**City of Portland, Maine - Building or Use Permit Application**

Permit No: 01-1503	Issue Date: DEC 19 2001	CBL: 337 C093001
-----------------------	----------------------------	---------------------

Location of Construction: 79 Stuart St	Owner Name: Jimino Alphonso &	Owner Address: 79 Stuart St	Phone: 874-4946
Business Name:	Contractor Name: no contractor/self	Contractor Address: n/a n/a	Phone:
Lessee/Buyer's Name:	Phone:	Permit Type: Additions - Dwellings	Zone: R-3

Proposed Project Description:  
remove 10' x 14' deck and legalize shed  
*be sure removed*

THIS IS NOT A BOUNDARY SURVEY

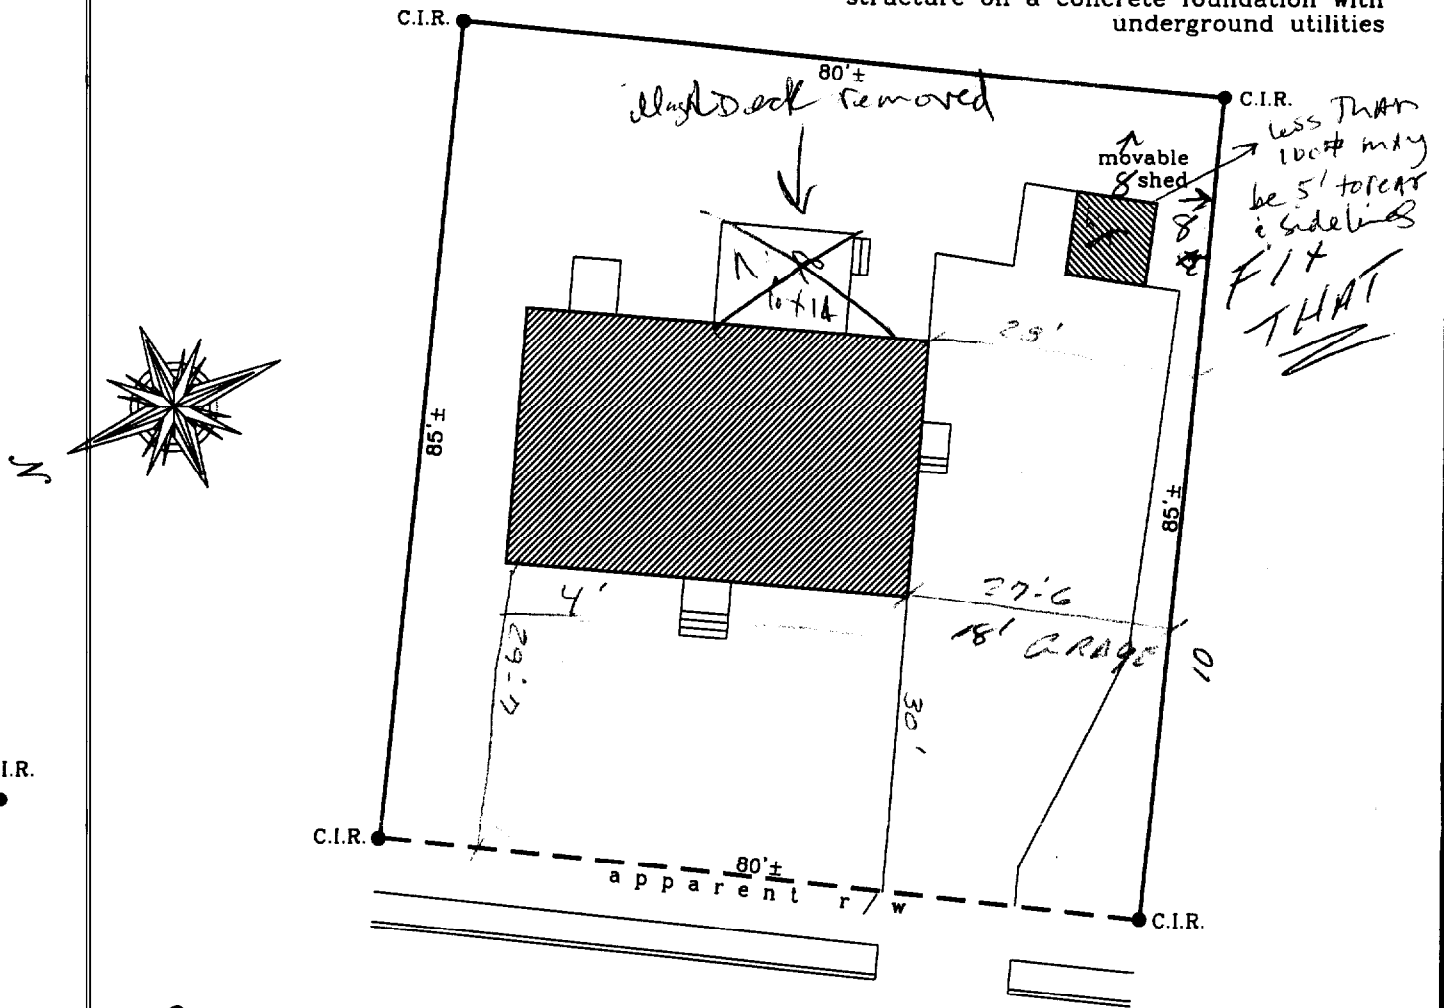
Please note, as I related to you by phone, that my research of our files indicates that there have been no permits for several of the present structures on site. I do not find a permit, or variance to allow the rear 10' x 14' deck. This deck, according to your submitted plot plan, shows only a 19.5 foot rear setback instead of the required 25 foot. This deck shall be made to conform to the current zoning and building codes, by applying for a permit and adjusting its size to meet the required rear setback of 25 feet. It may also be removed to gain compliance.

The rear 8.5' x 8.5' shed also does not appear to have a permit on file. At present, the shed appears to meet the current setbacks for an accessory, detached structure, less than 100 square feet. However, to legalize this shed, it requires a permit and approvals thru this office.

My research did show that the rear bulkhead also extends into the rear setback. However, the Zoning Board of Appeals did grant a variance in 1991 for that rear setback for the bulkhead.

*12/12/01*  
*OK To issue permit*  
*GARAGE OK Now*  
*with illegal Deck removed*  
*& legalized The 8.5' x 8.5' Shed*

*12/10/01 - Deck removed - see permit # 01-1503*
